Ribble Valley Borough Council  
Development Control

Application no: 3/2020/0091  
Address: Land adj 5 Beech Close Clitheroe  
Proposal: Erection of 2 dwellings

Sketch Proposed Site Layout
1:500

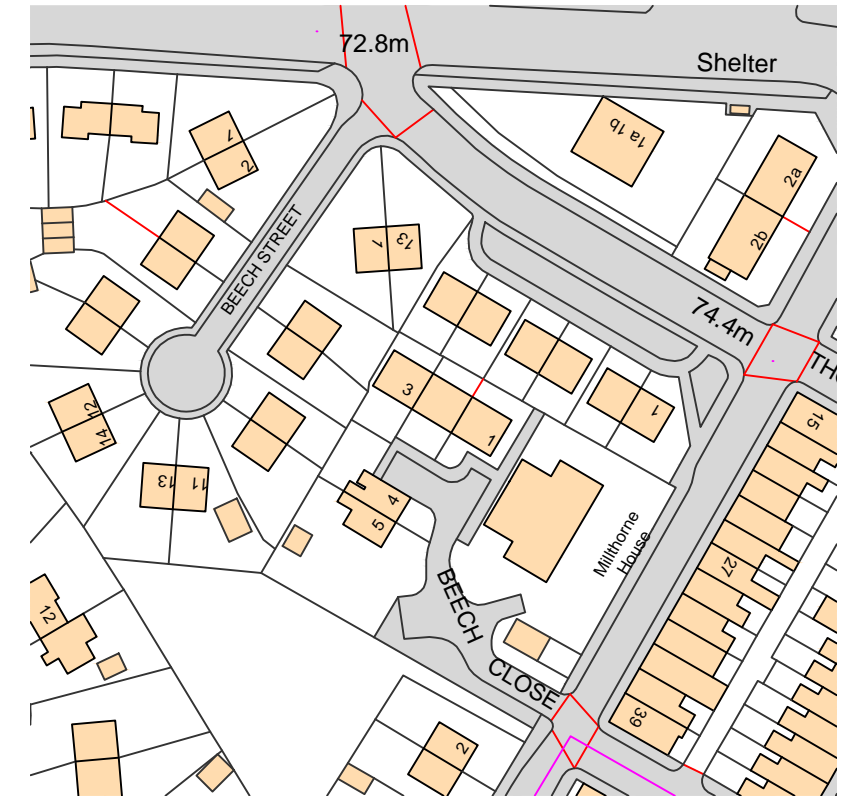
1 The existing unit no. 5 only has 1 allocated parking space. For a 2 bed property this should be increased to 2 spaces
